STATE OF NORTH CAROLINA
DEPARTMENT OF TRANSPORTATION

Addendum No. 1

RE: Contract ID: C201604
WBS # 33066.3.2
F.A. # BRSTP-1243(4)
Davidson County (B-3446)
Bridge over Norfolk Southern Railroad and
Approaches on SR 1243

August 21, 2007 Letting

REVISIONS						SHEET NO.
NO.	BY:	DATE:	NO.	BY:	DATE:	S-3
1			3			TOTAL SHEETS
2			4			30

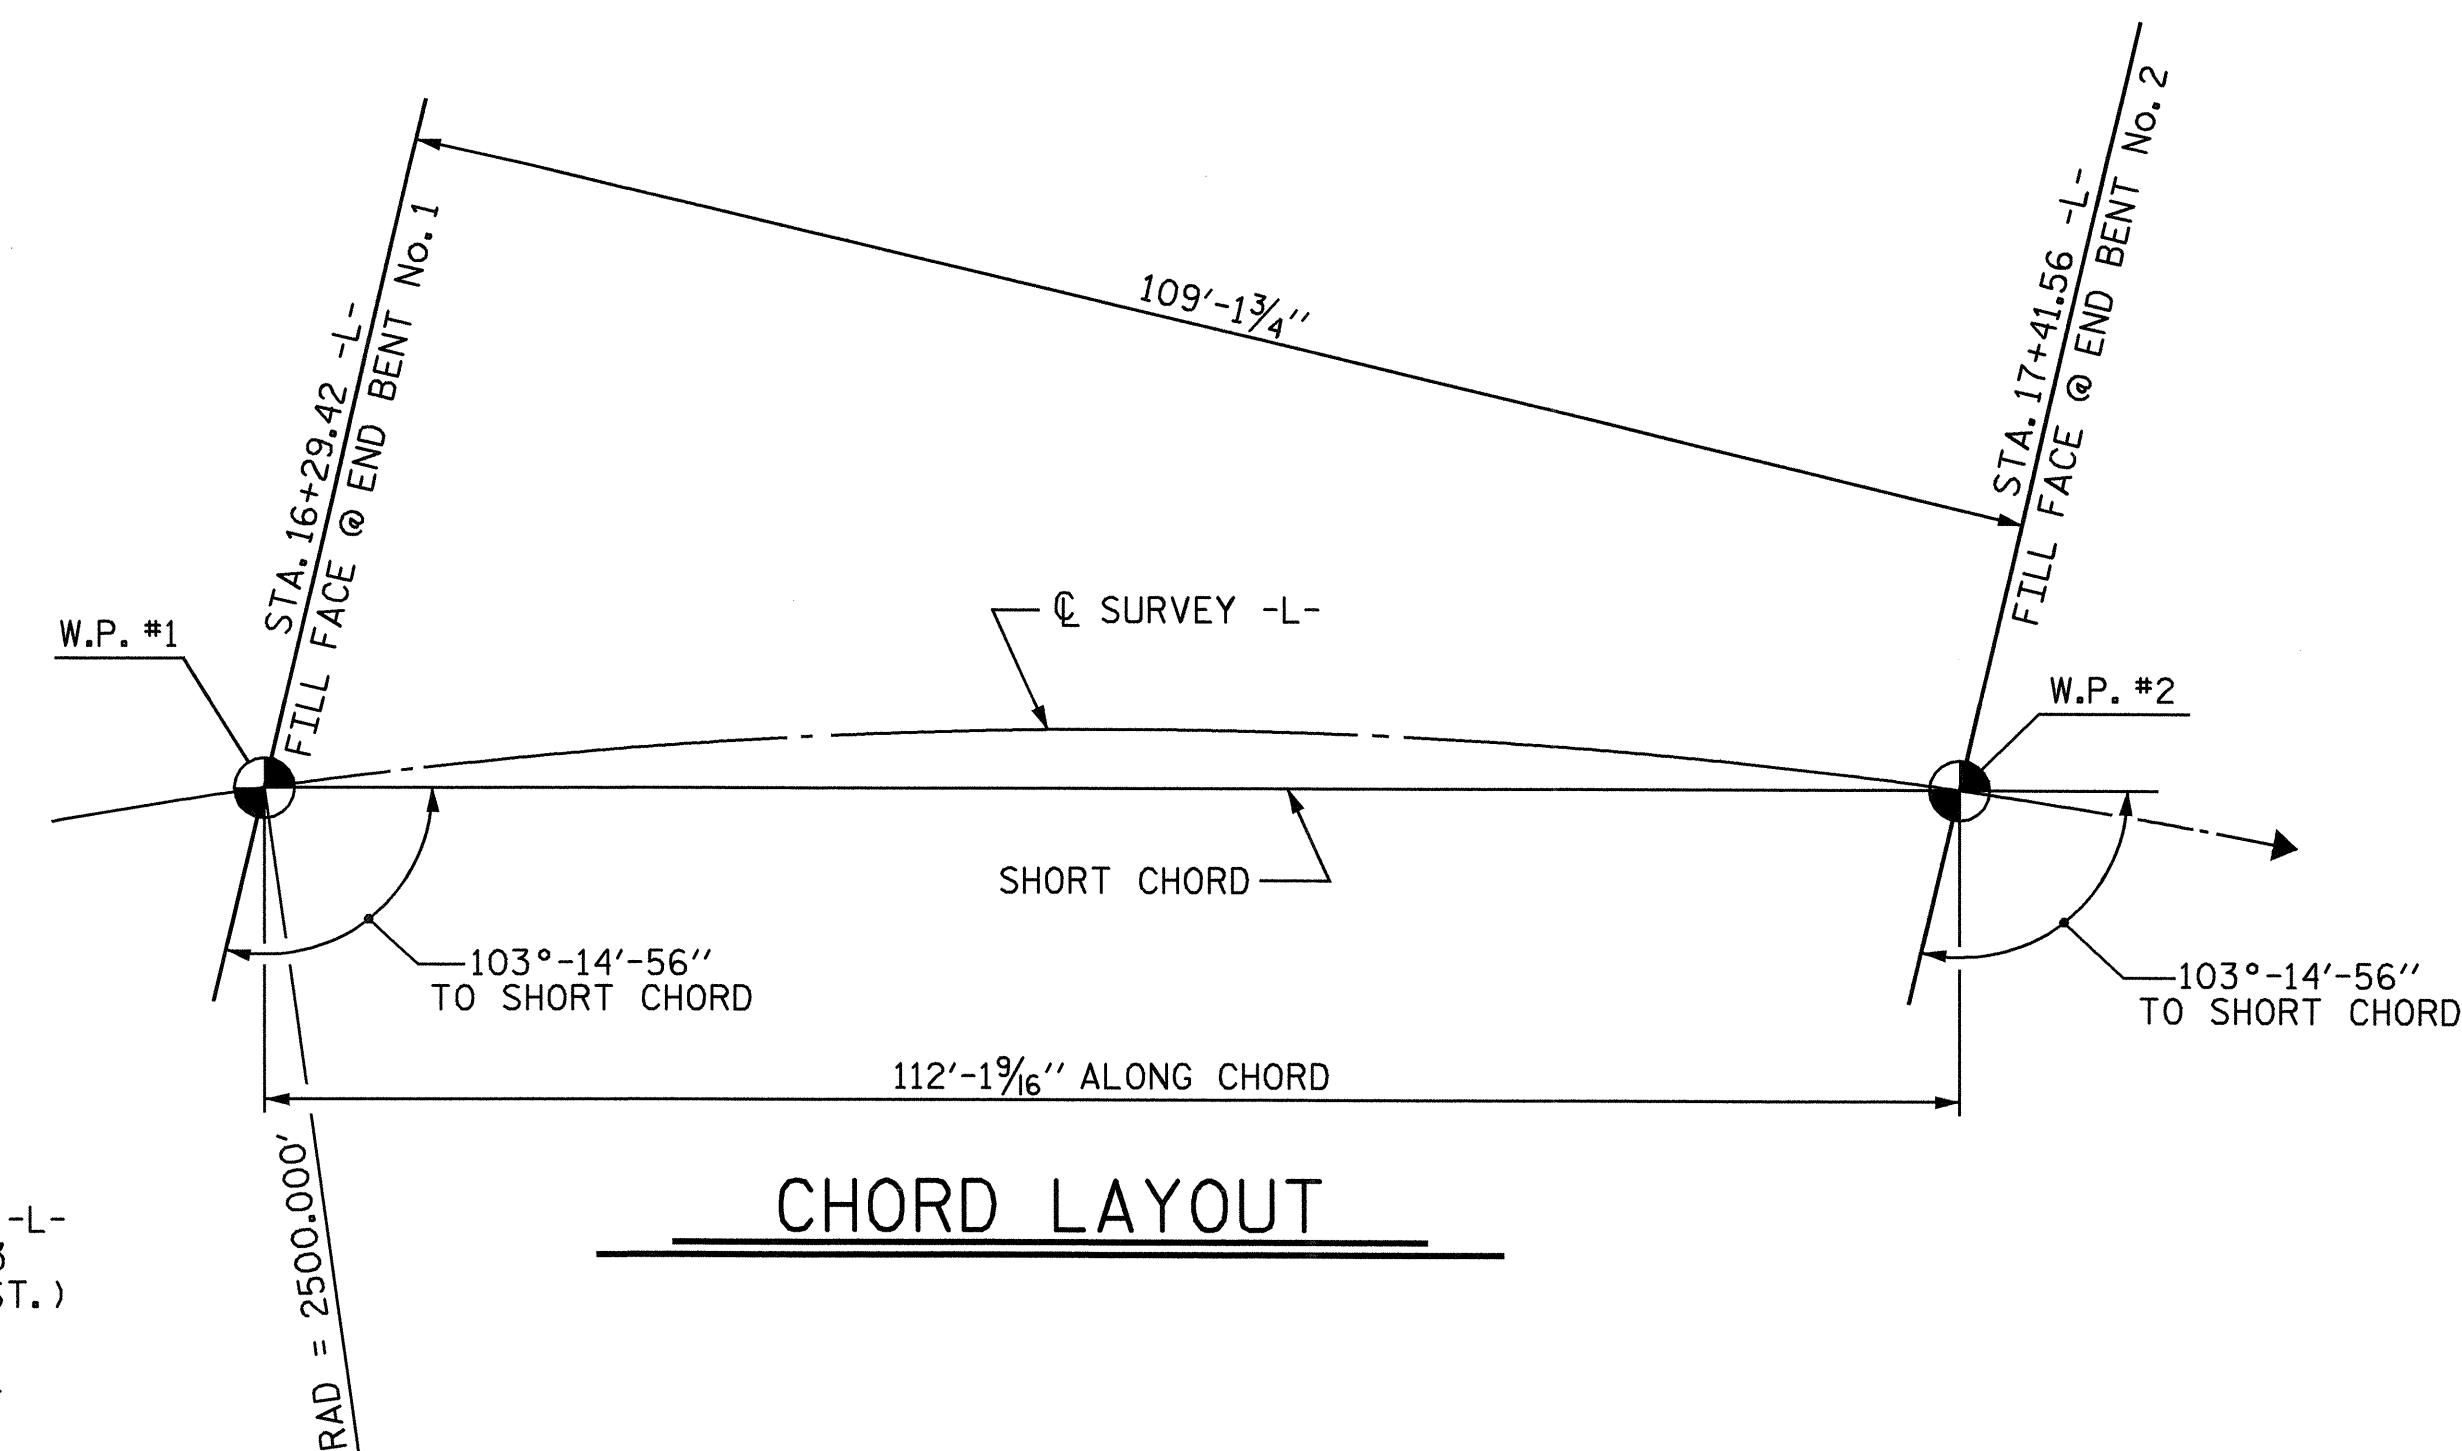
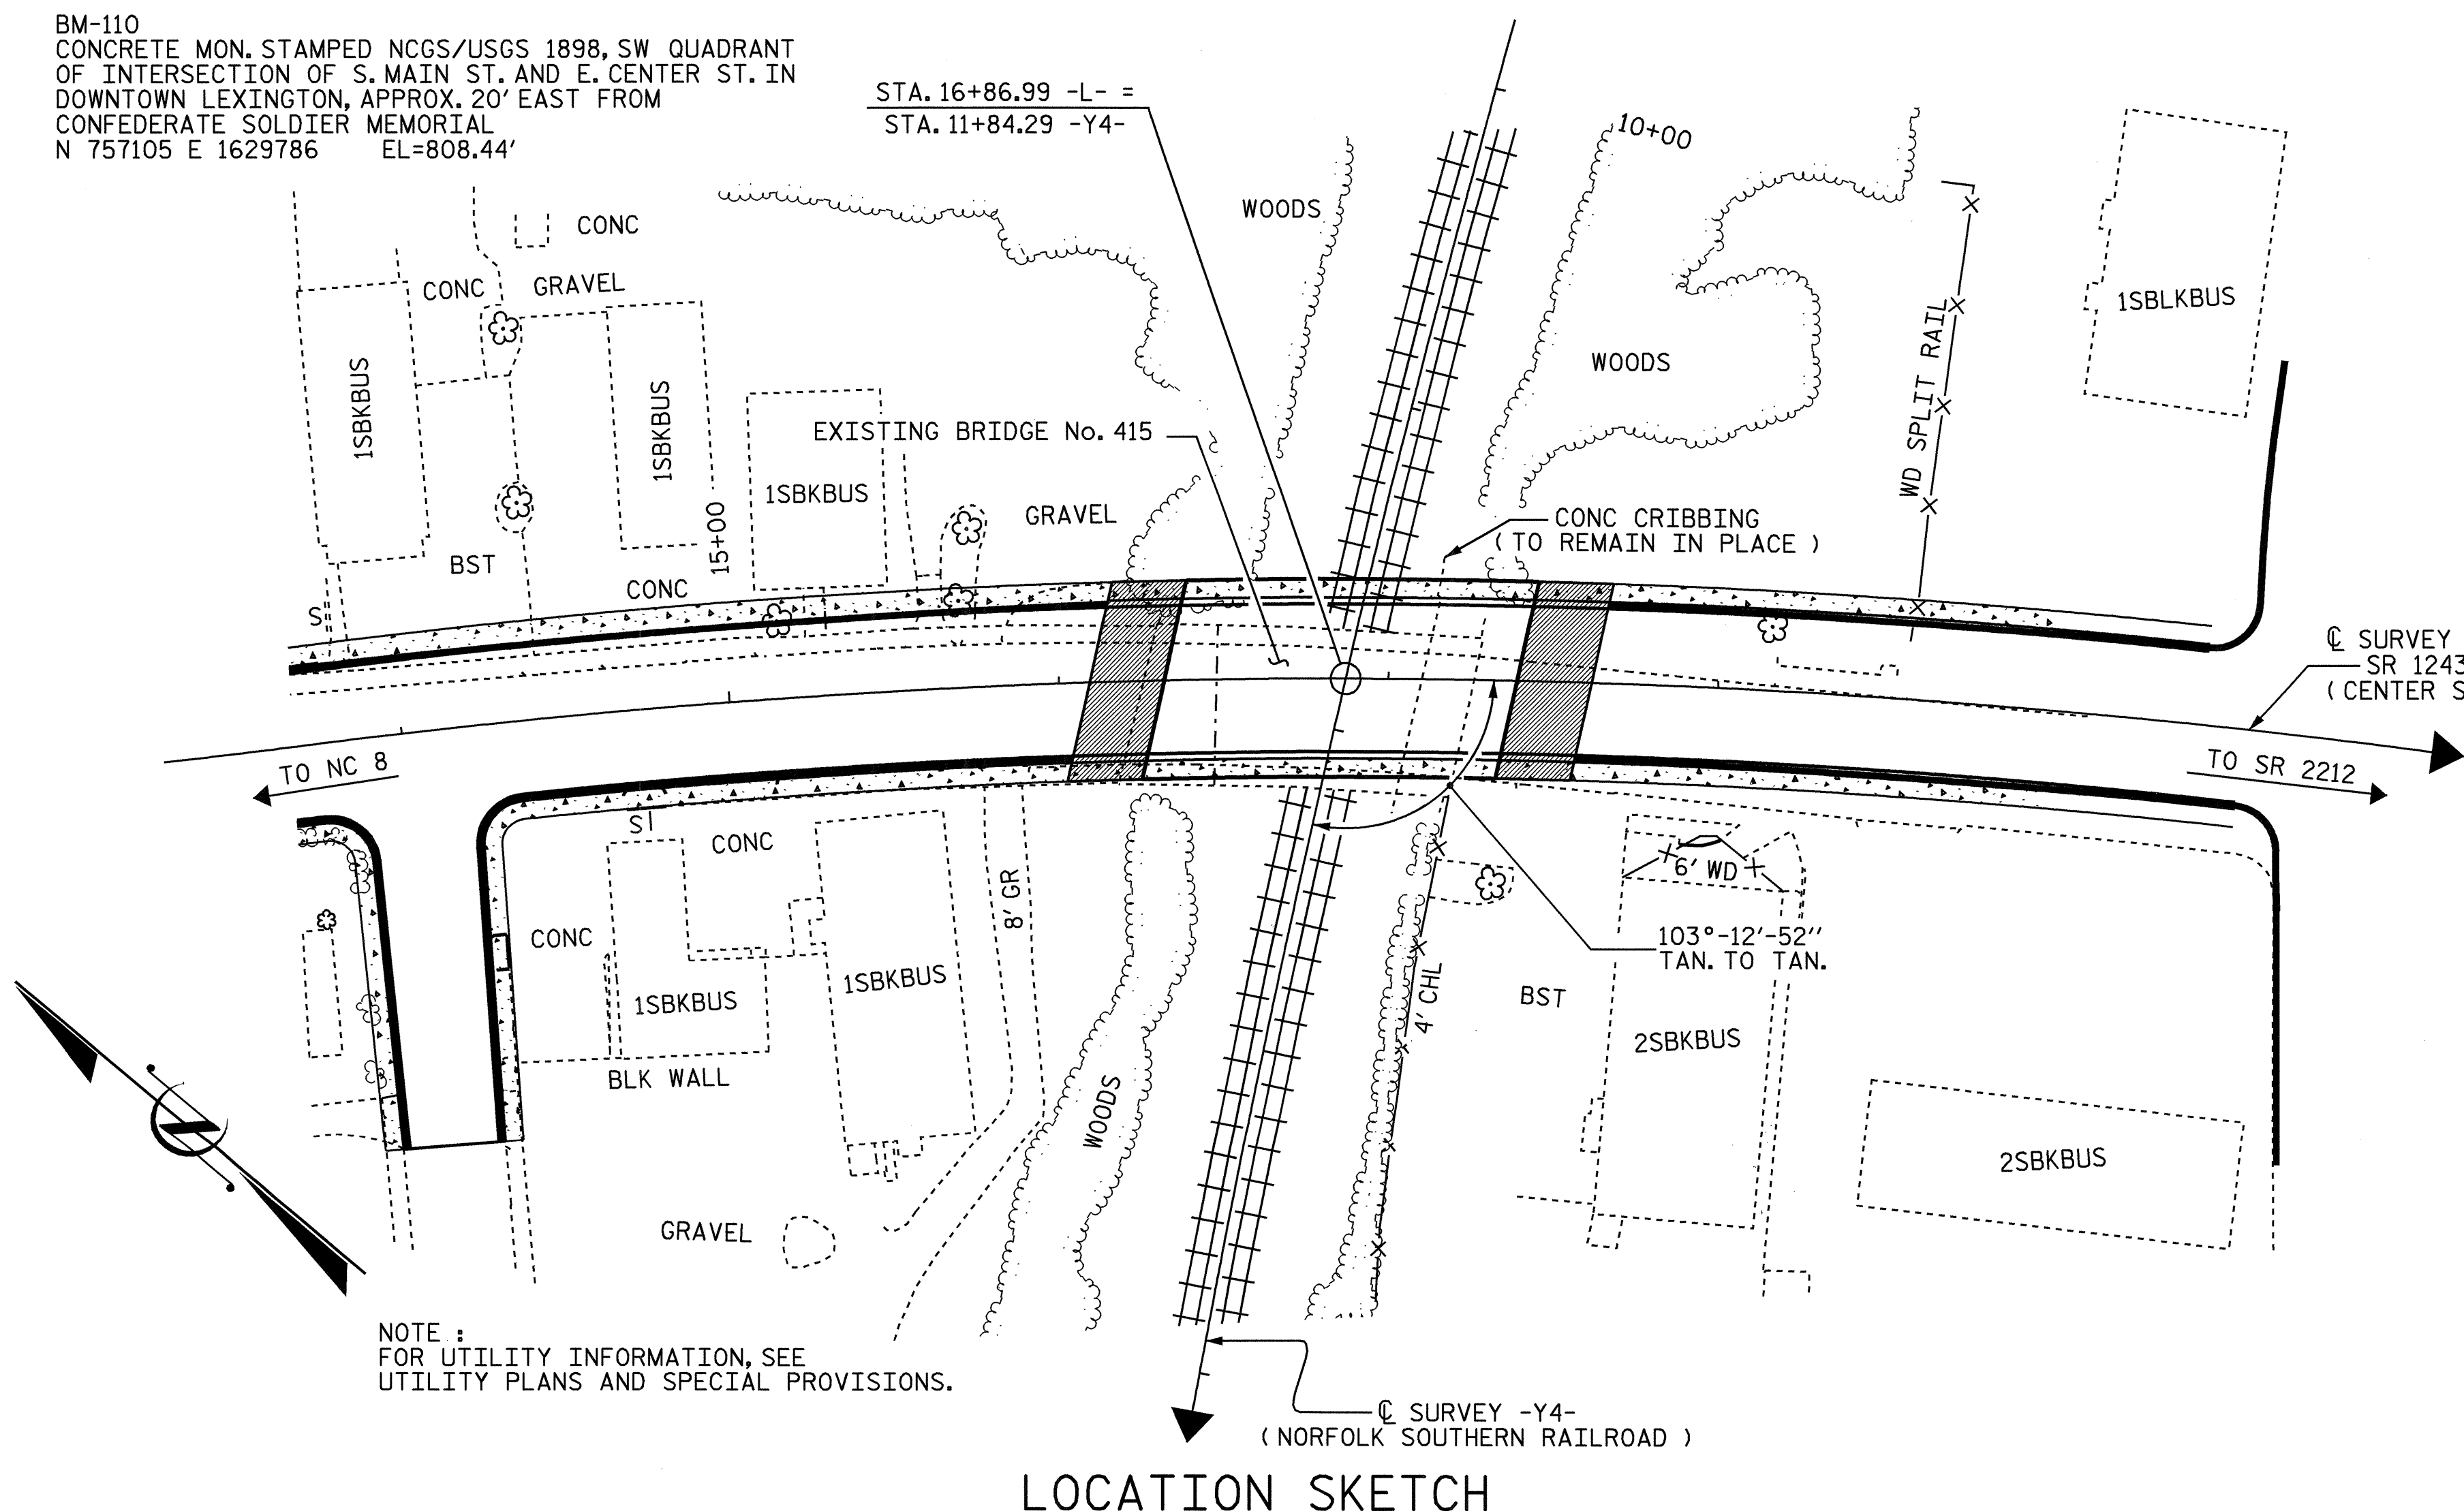
The following sheets in the Structure plans have been revised: Sheet Nos. S-2, S-3, S-7, S-8, S-9 and S-10.

Various notes and dimensions have been revised on these sheets as a result of changing from "High Performance Steel (HPS 70W)" to "AASHTO M270 Grade 50W".

Please void Sheet Nos. S-2, S-3, S-7, S-8, S-9 and S-10 in your plans and staple the revised Sheet Nos. S-2, S-3, S-7, S-8, S-9 and S-10 thereto.
